Inspector's Report ABP-313720-22

Strategic Housing Development

224 no residential units (22 no. houses and 202 no. apartments), crèche and associated site works.

Kilmoney (townland), Kilmoney Road, Carrigaline, Co. Cork.

1 **GA - ELEVATION - EAST 01 - TOWNHOUSES**  
 1 : 200

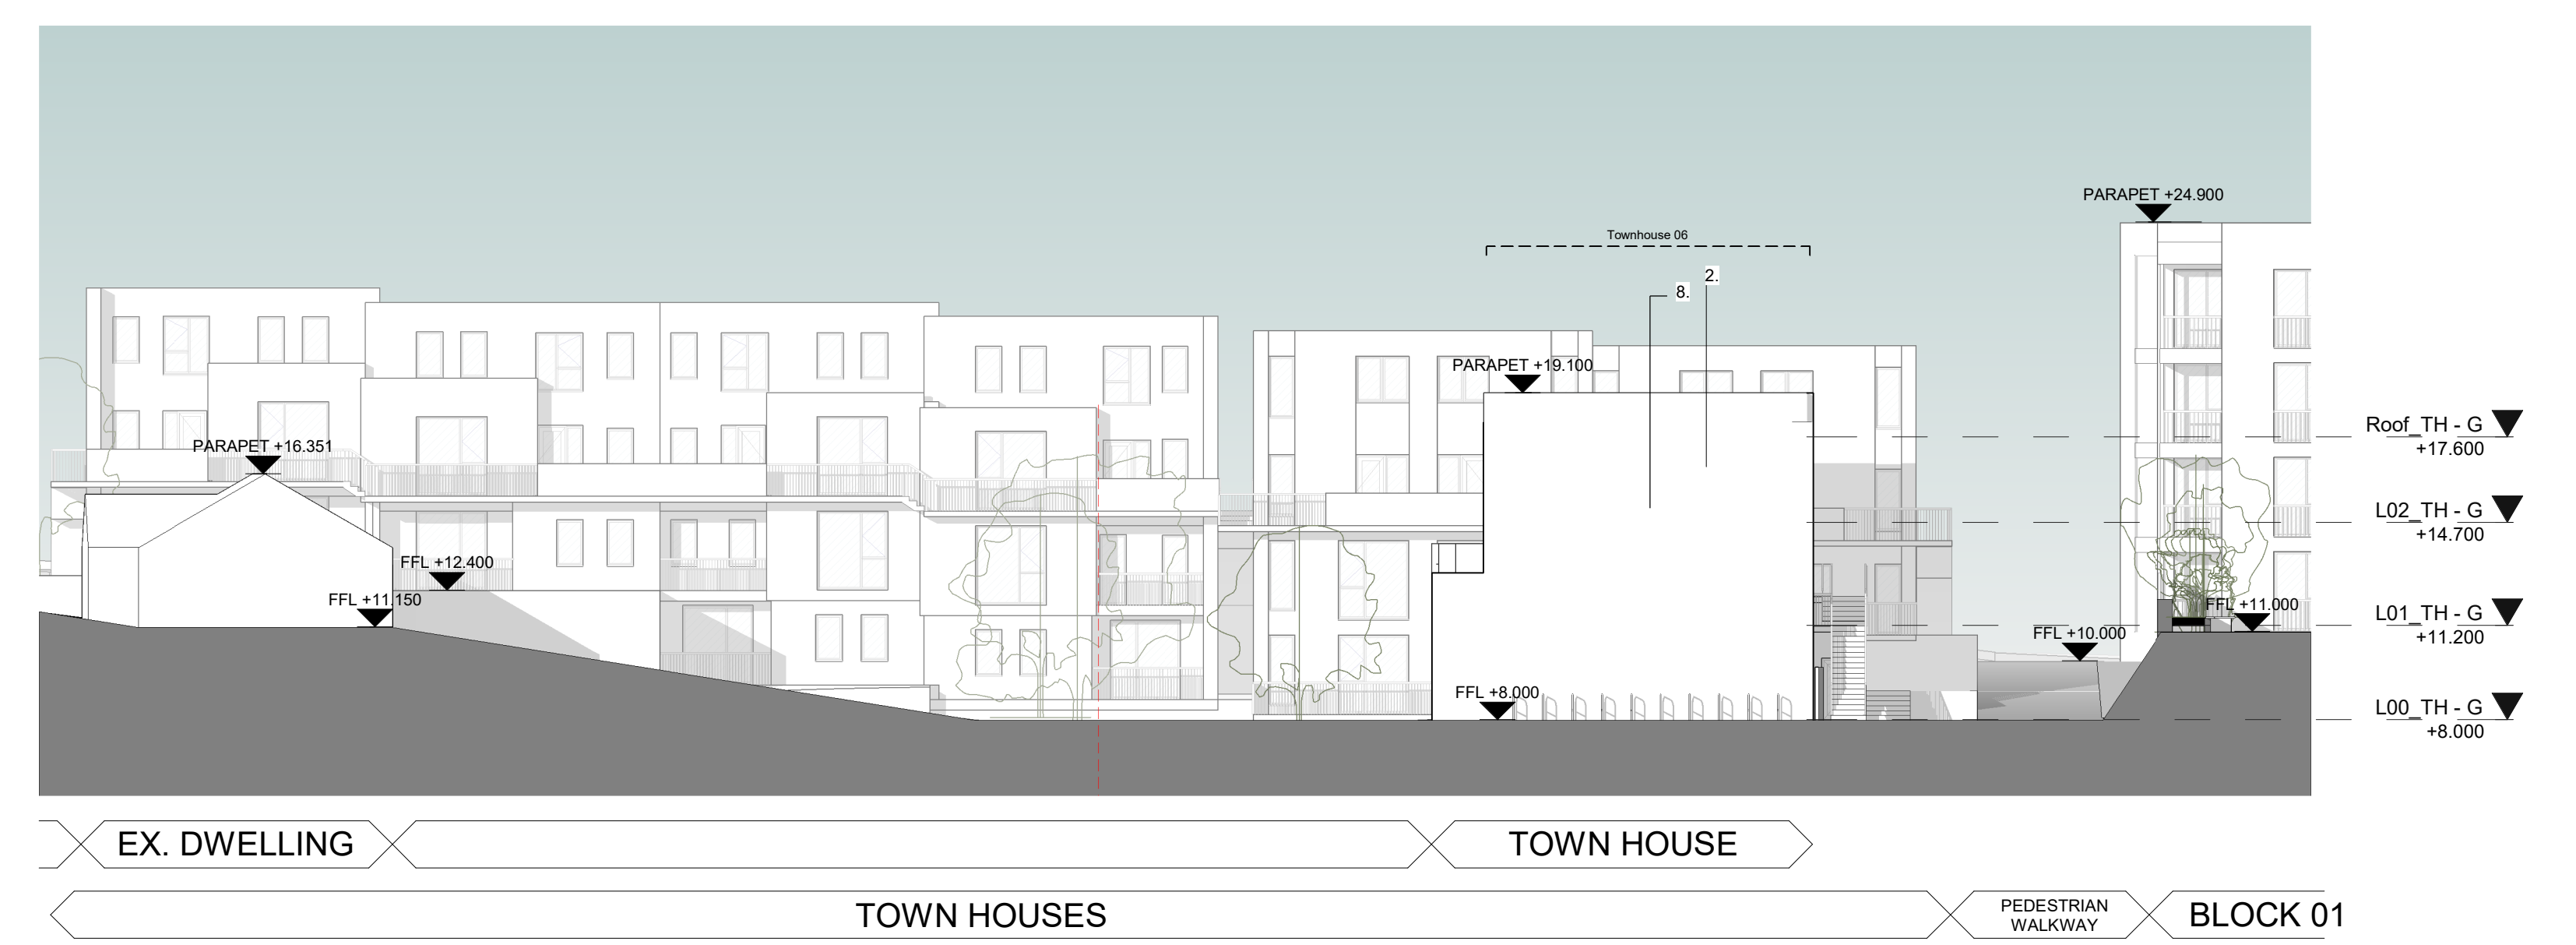
3. Revised plan submitted prior to the commencement of development reconfiguring block containing proposed townhouses/duplexes units (3A, 3B, 4A, 4B, 4C, 4D, 5A) so as not to exceed 2-storeys in height above ground level.
5. Prior to the commencement of development, to submit proposals to deliver the pedestrian bridge including timeline in accordance with Mapped Objective CL-U-03.
9. Prior to the commencement of development, the applicant shall submit a revised storm/surface water management plan to include additional capacity to cater for climate change uncertainty in accordance with best practice standards. The revised system shall incorporate on site attenuation and nature-based surface water drainage measures and SuDS.
